SYDNEY UNIVERSITY BOAT CLUB

13 November 2019

Re SSD 8924 - New Sydney Fish Market Concept and Stage 1 Early Works

**Diagram : Existing Blackwattle Bay / Rozelle Bay Rowing Course**

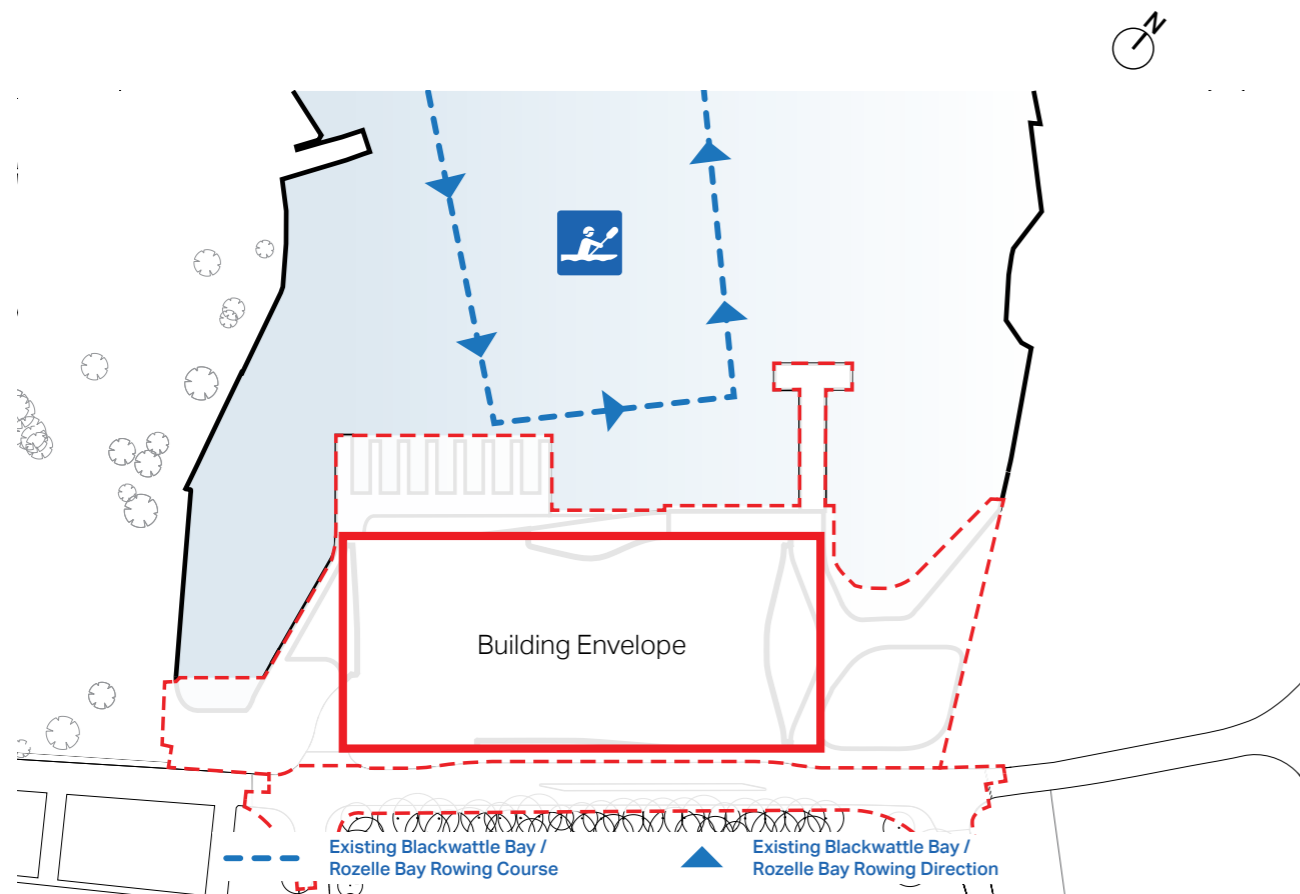
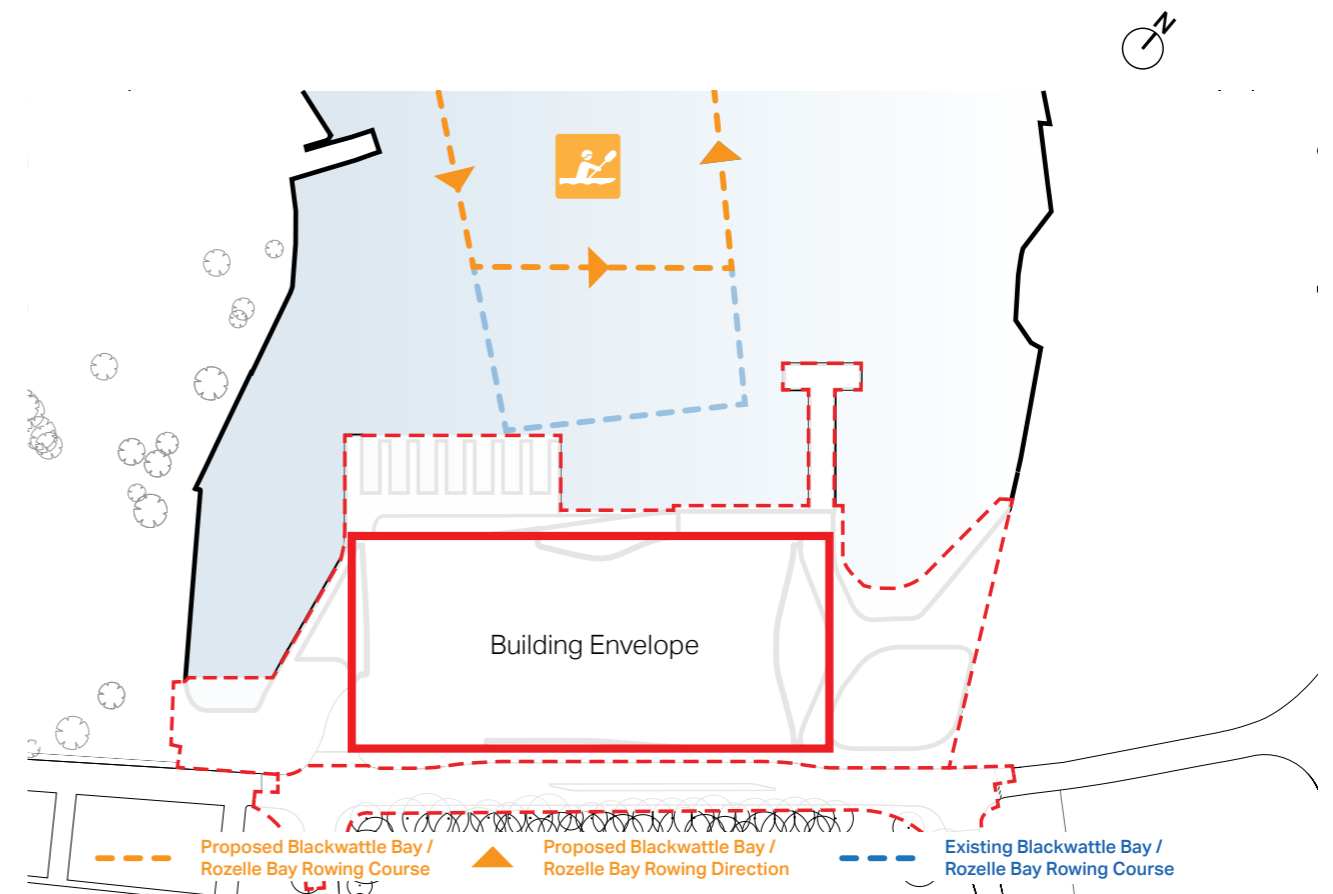
Also, we note that the apparent impact of the development on the rowing course is lessened by the omission of Glebe Rowing Club and its pontoon from most of the major relevant diagrams including those in A3 Vol Appendix 1 Concept Drawings and A3 Vol

Appendix 2 Concept Design Report Part 3. Inclusion of this structure would make the distances clearer, and better indicate how much of the course is proposed to be lost.

The proposed public ferry and recreational wharf extends 35 m beyond the proposed trawler wharves, into the current agreed rowing course (Fig 21 in NIA) and overlaps the rowing route up the east side of the Bay. We currently muster and turn where the Eastern wharf is proposed. Even with the length of course reduced by 45-50m, we would still be turning within about 20 m of the proposed wharf – an unsafe distance.

One reason why the problem of the eastern wharf is not so obvious in the NIA is because the agreed rowing course (Fig 21 on p.21) has not been transferred accurately to the “indicative” Diagrams on pp 43-44. The course negotiated by RMS and Rowing NSW allows safe passage up and down the Bay by providing a course width of approximately 115-150m. The width appears to have been reduced in the indicative diagrams to perhaps 90 -100m. Such a width suggests a lesser interaction between ferries on the extended wharf and rowing boats, but would increase the risk of collision between rowing craft and motorized vessels travelling up and down the Bay.

We request that the public wharf be shortened by at least 25 m to provide safe clearance to turning rowing boats.

**Diagram : Wharf - Recreational And Ferry**

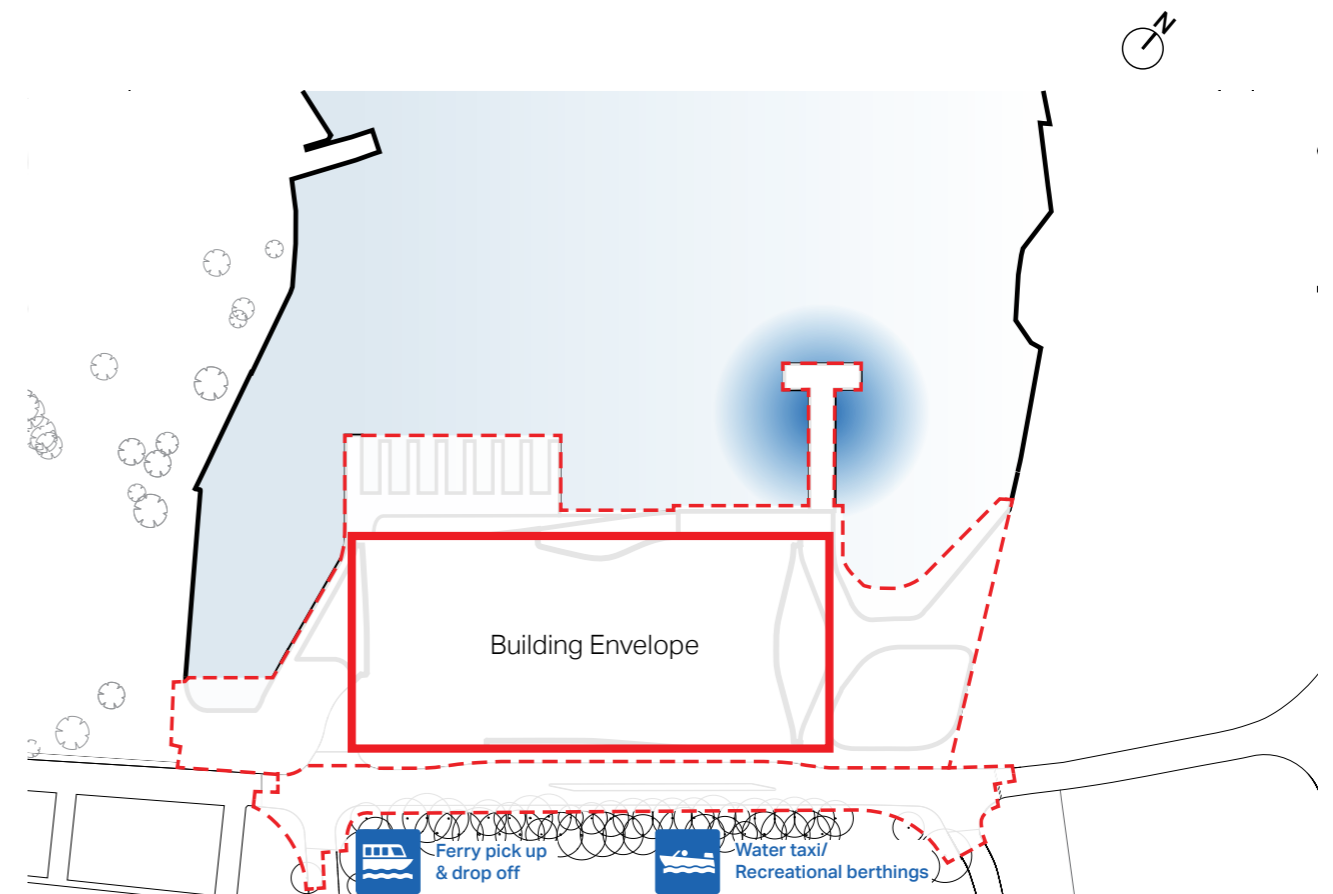
We note that the NIA projects that private motorized vessel access to the new Market is expected to increase, but no estimates of current or projected usage are provided to substantiate such a large wharf.

- There appear to be no estimates of day-tripper arrivals to the Fish Markets by small powered vessels – either currently or into the future – to justify the size and positioning of the Eastern wharf.
